Ribble Valley Borough Council
Planning Section
Council Offices
Church Walk
Clitheroe
BB7 2RA

Phone: 0300 123 6780
Email: developeras@lancashire.gov.uk
Your ref: 3/2026/0332
Our ref: 3/2026/0332/HDC/LB
Date: 22/05/2026

Location: Land at Lower Standen Hey Farm, Whalley Road, Pendleton, BB7 1PP
Proposal: Reserved matters application for appearance, landscaping, layout and scale for the erection of a farm worker's dwelling (self-build)

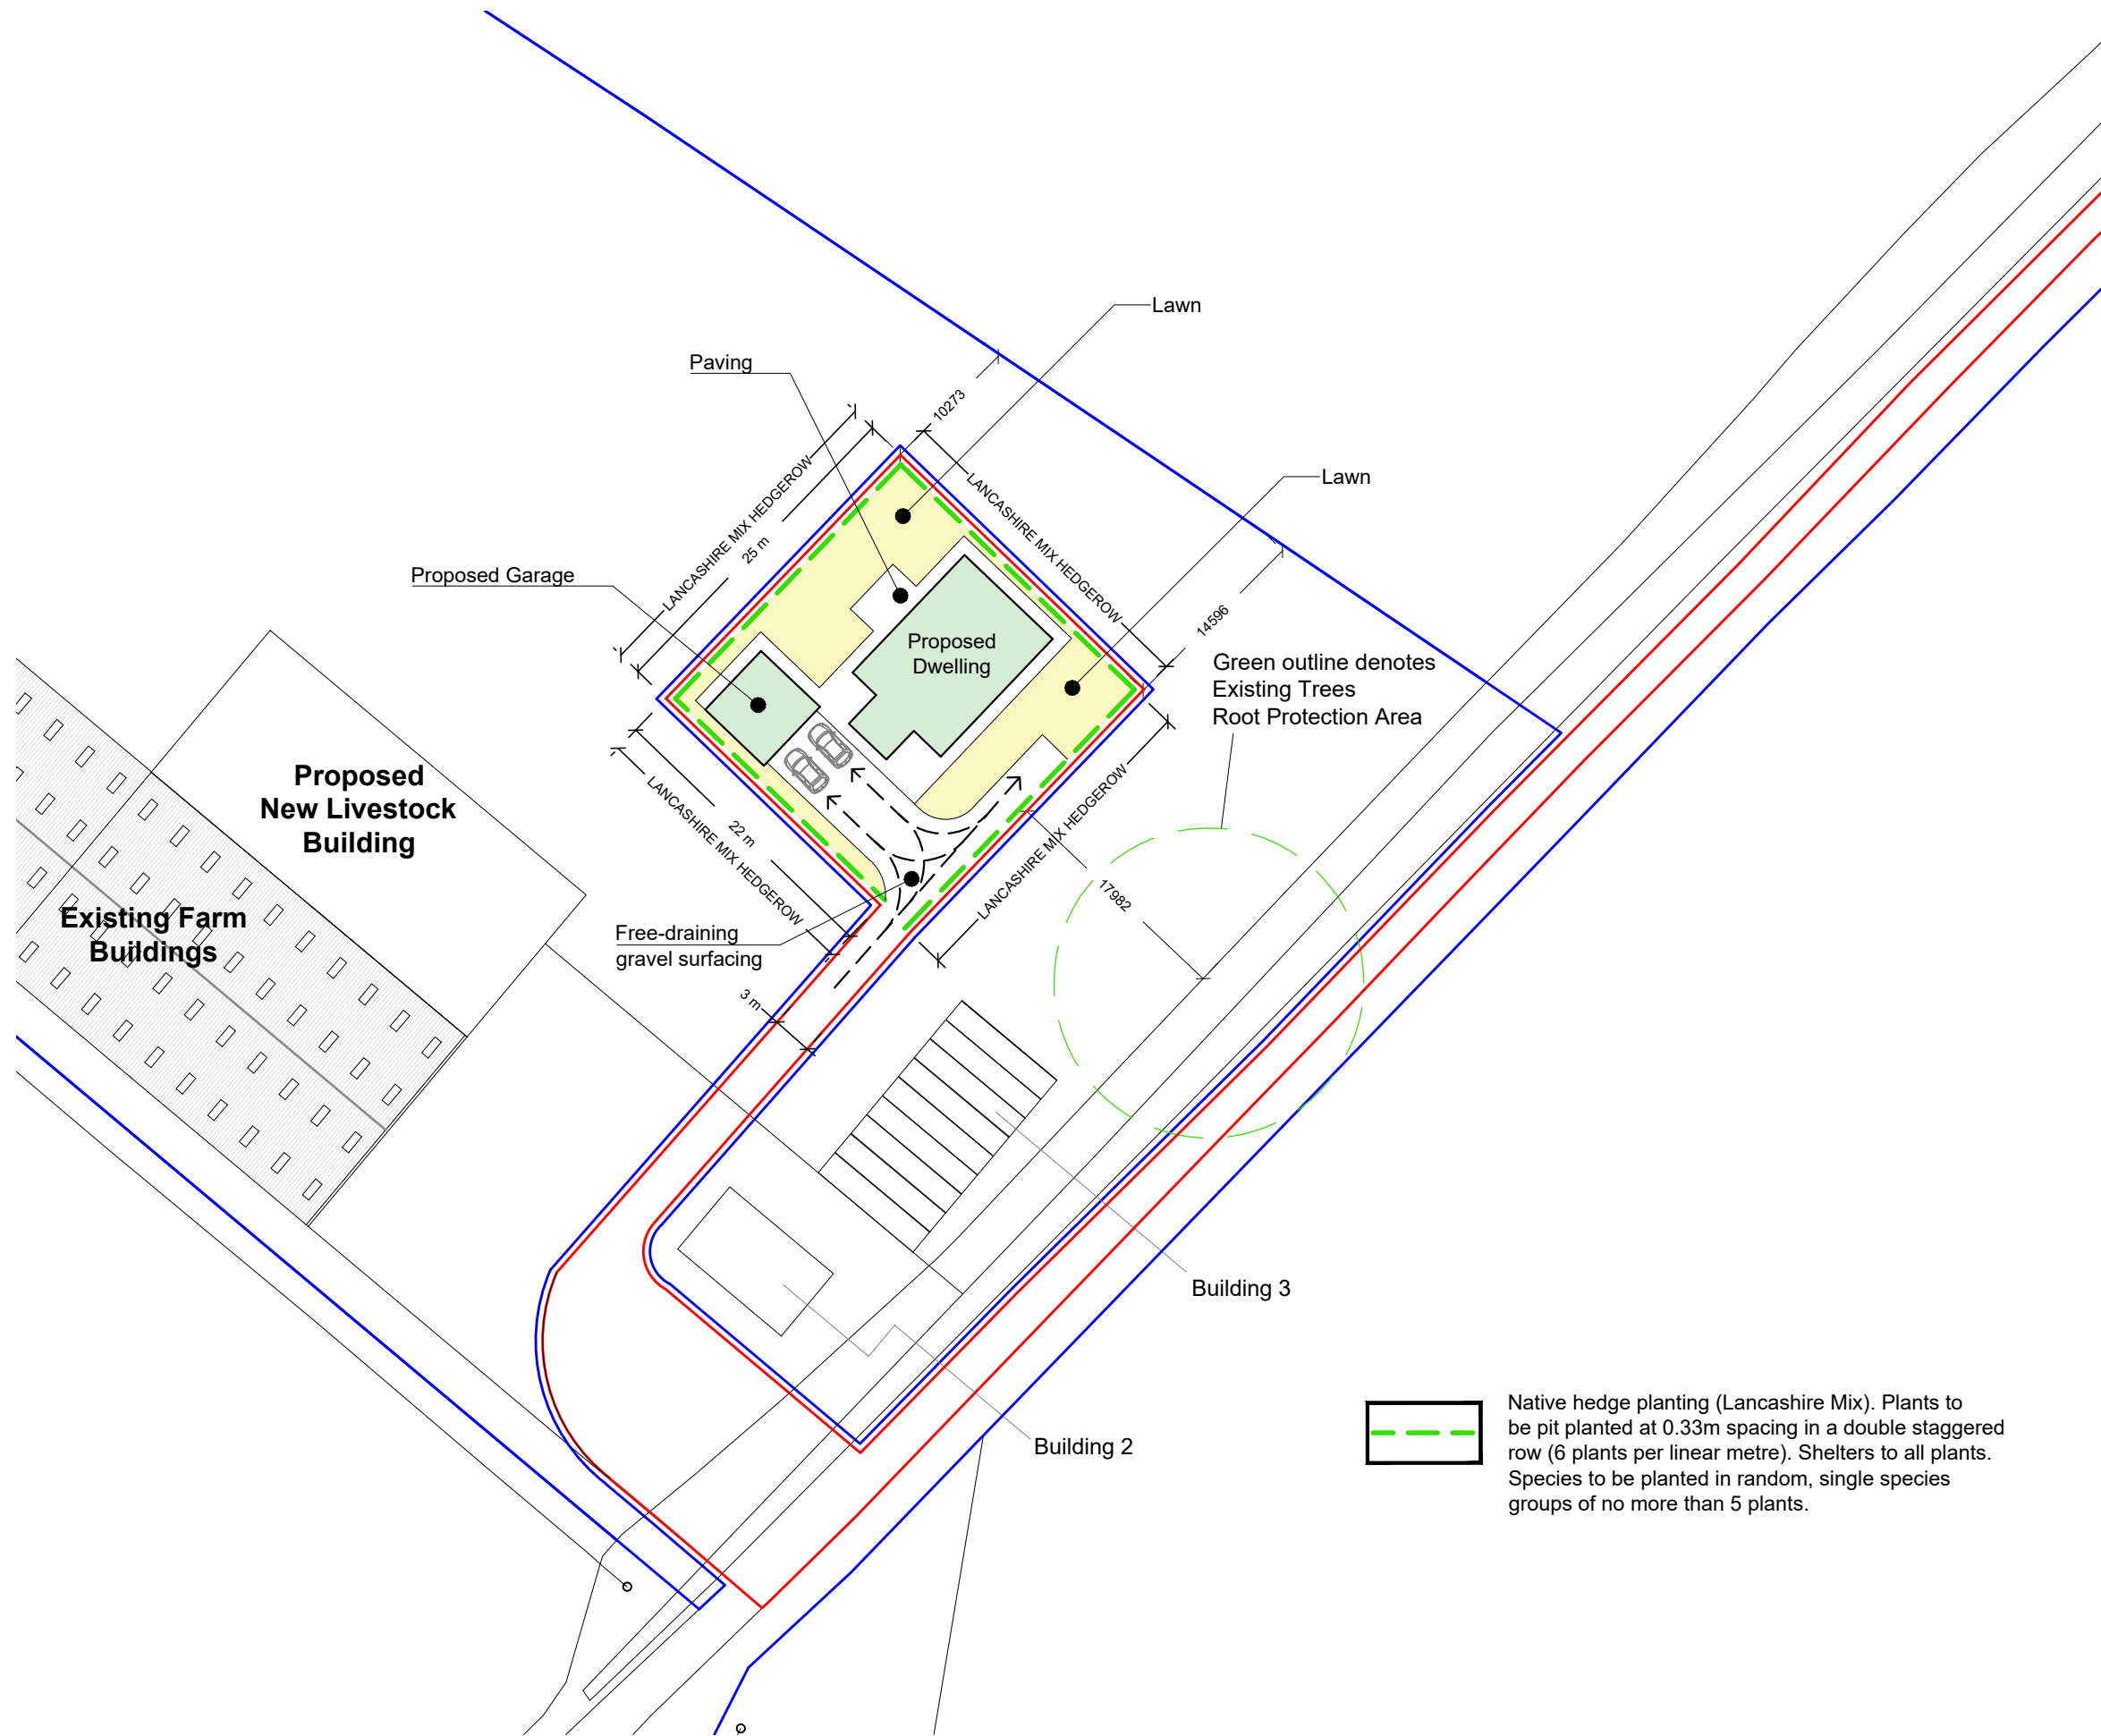
Whilst the proposed garage's internal dimensions fall short for achieving two off street parking spaces, it does have the capacity to accommodate one space.

The site has adequate space for achieving off street parking for the scale and size of the development.
